September 18, 2019

Re: Place at Nob Hill
3339 Central Ave NE Albuquerque NM
Traffic Circulation Layout
Engineer's/Architect's Stamp 09-11-19 (K16D069)

Based upon the information provided in your submittal received 09-17-2019, the above referenced plan cannot be approved for Building Permit until the following comments are addressed:

NORTH
 1" = 20'-0"
 0 10' 20' 40'
GARAGE FLOOR PLAN and STREET SITE PLAN (OVERALL)

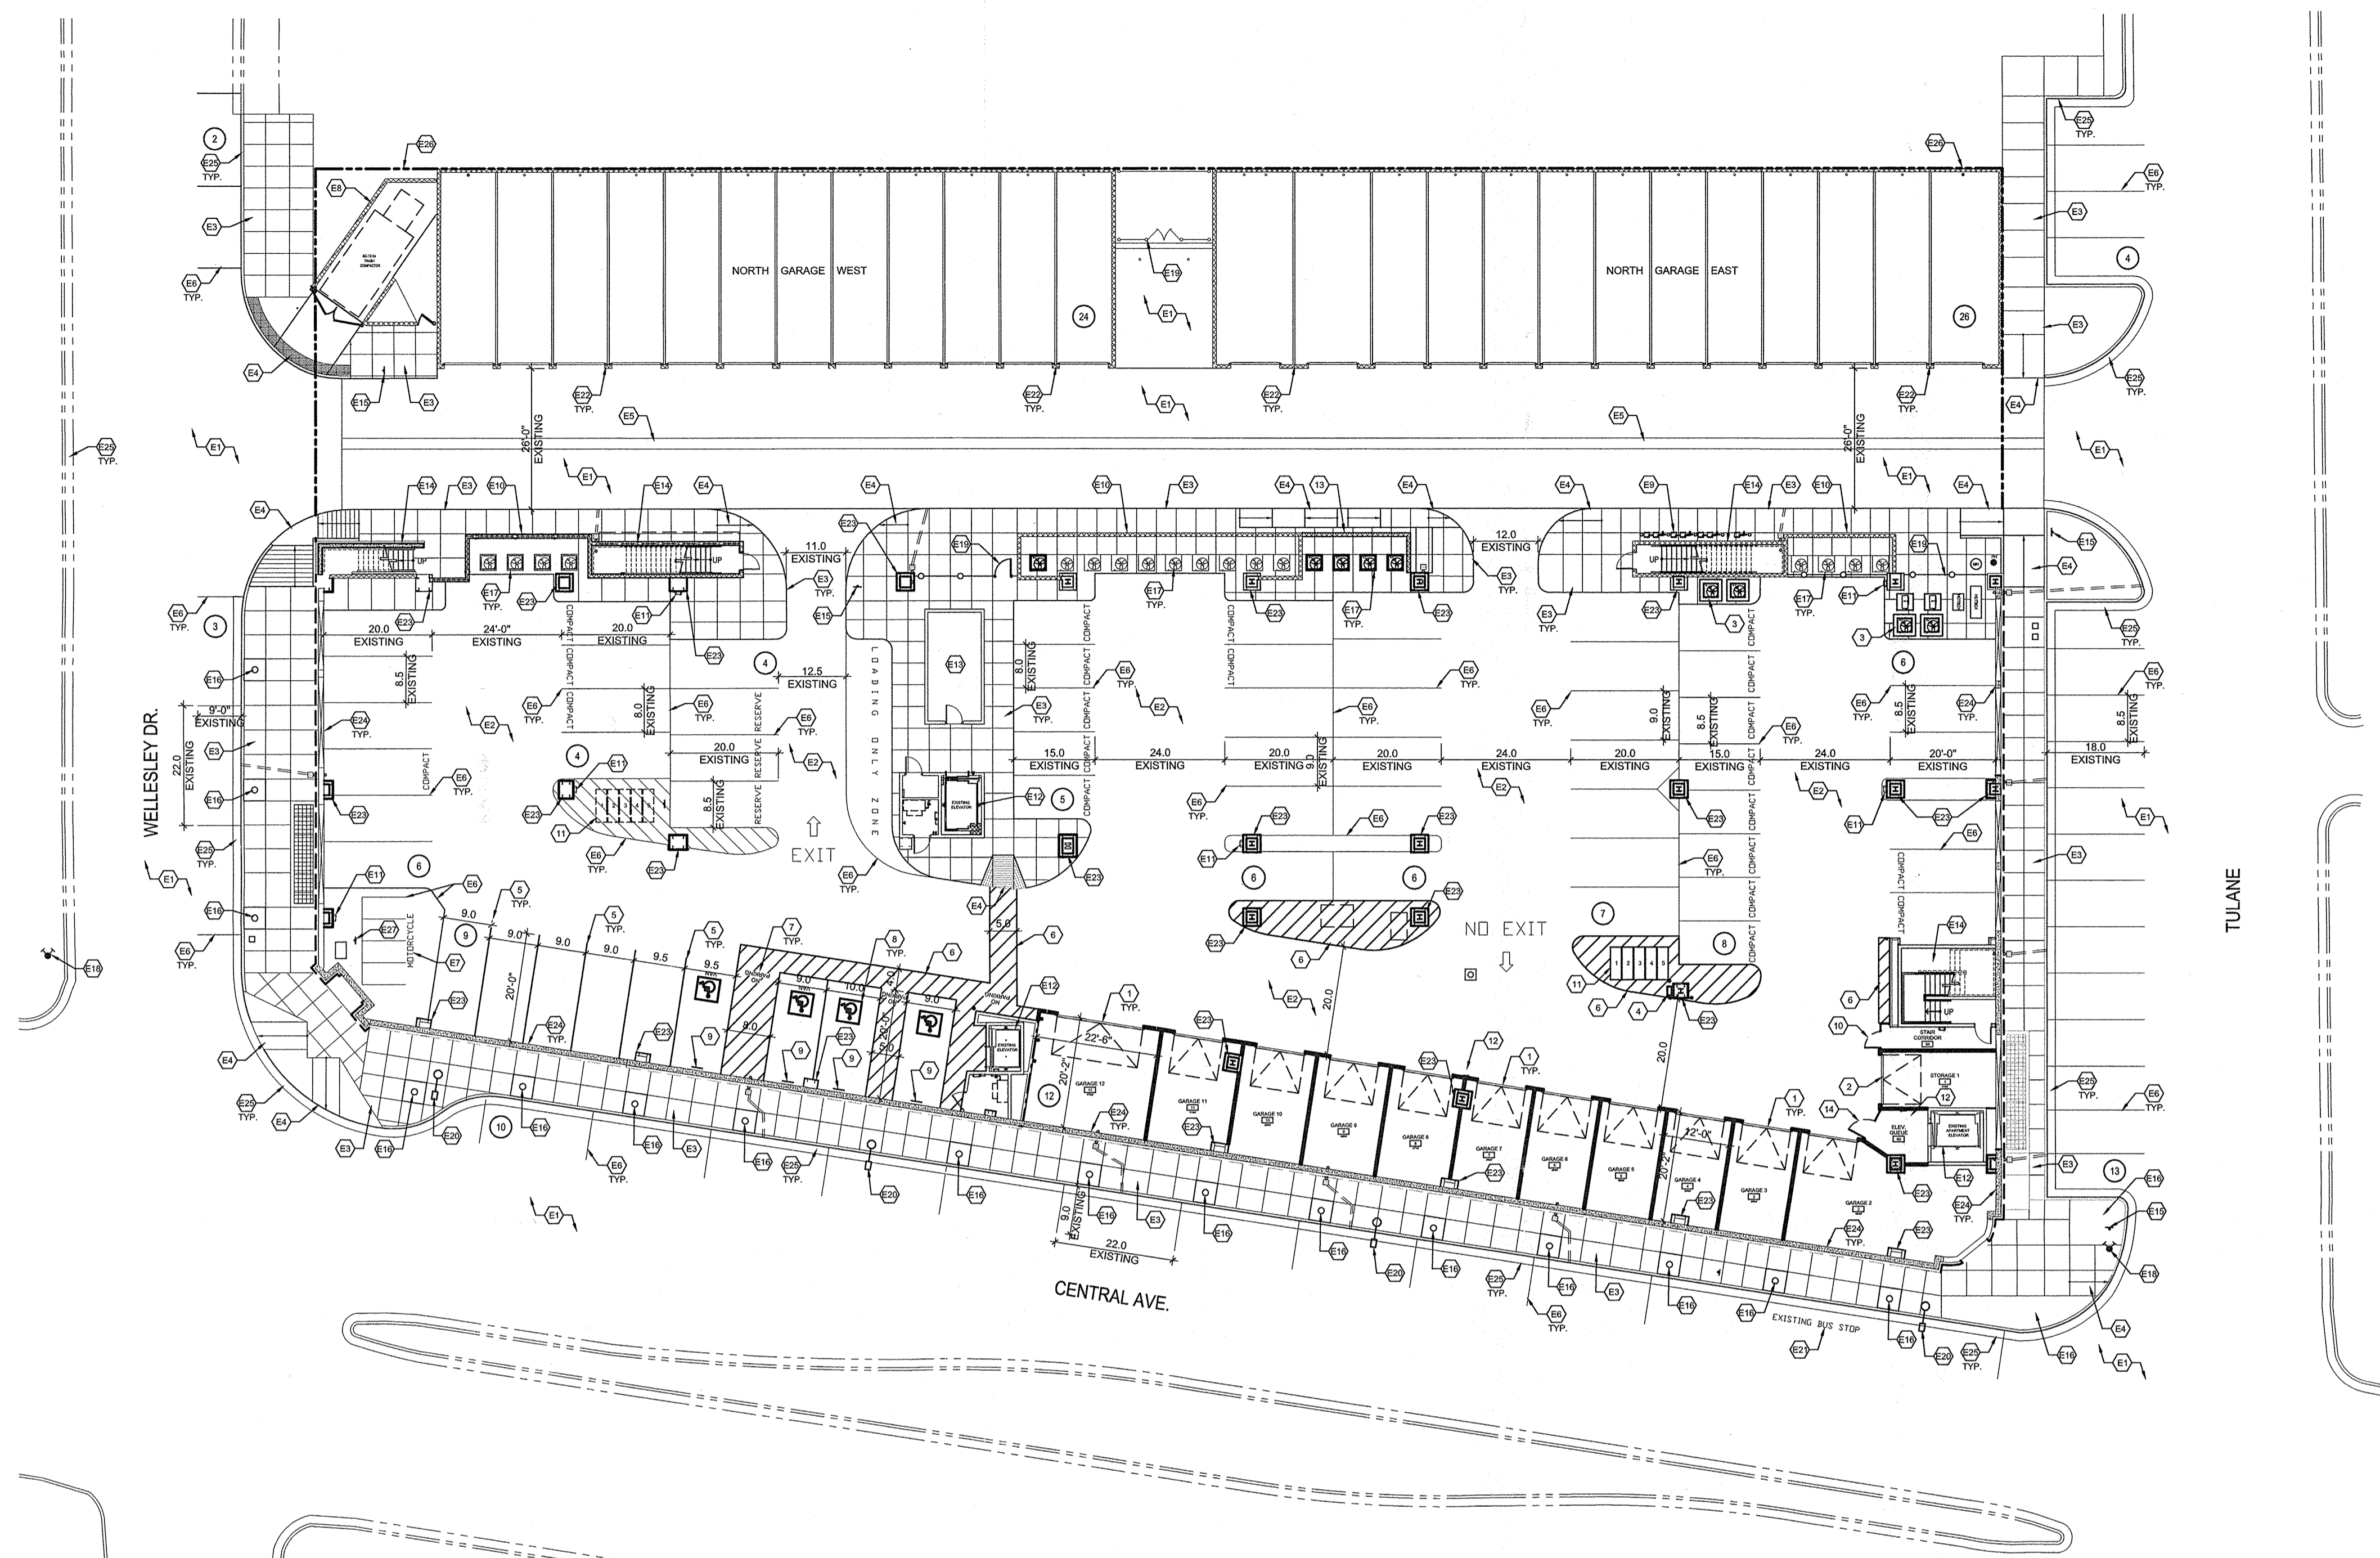
1. Per the Development Process Manual, Chapter 27 Drafting Standards, "Standard sheets must be 24" by 36" having a margin of 2' along the left and 1" on the top and bottom".
2. A scale of 1"=20' is recommended for sites less than 5 acres.
3. A scale of 1"=50' is recommended for sites 5 acres or more.
4. The scale must be shown on the plan. Per the Development Process Manual, Chapter 27, Section 2, Part B.1, on the following scales may be used:

1" = 20'	1" = 40'
1" = 50'	1" = 100' (for overall layouts only)
5. The ADA access aisles shall have the words **"NO PARKING"** in capital letters, each of which shall be at least one foot high and at least two inches wide, placed at the rear of the parking space so as to be close to where an adjacent vehicle's rear tire would be placed. (66-1-4.1.B NMSA 1978)

6. Motorcycle parking spaces shall be designated by its own conspicuously **posted upright sign**, either free-standing or wall mounted per the zoning code.

7. All bicycle racks shall be designed according to the following guidelines:
 - a. The rack shall be a minimum 30 inches tall and 18 inches wide.
 - b. The bicycle frame shall be supported horizontally at two or more places. Comb/toaster racks are not allowed.

- c. The rack shall be designed to support the bicycle in an upright position. See the IDO for additional information.
 - d. The rack allows varying bicycle frame sizes and styles to be attached.

- e. The user is not required to lift the bicycle onto the bicycle rack.
- f. Each bicycle parking space is accessible without moving another bicycle.
- 8. Bicycle racks shall be sturdy and anchored to a concrete pad.
- 9. A 1-foot clear zone around the bicycle parking stall shall be provided.
- 10. Bicycle parking spaces shall be at least 6 feet long and 2 feet wide.
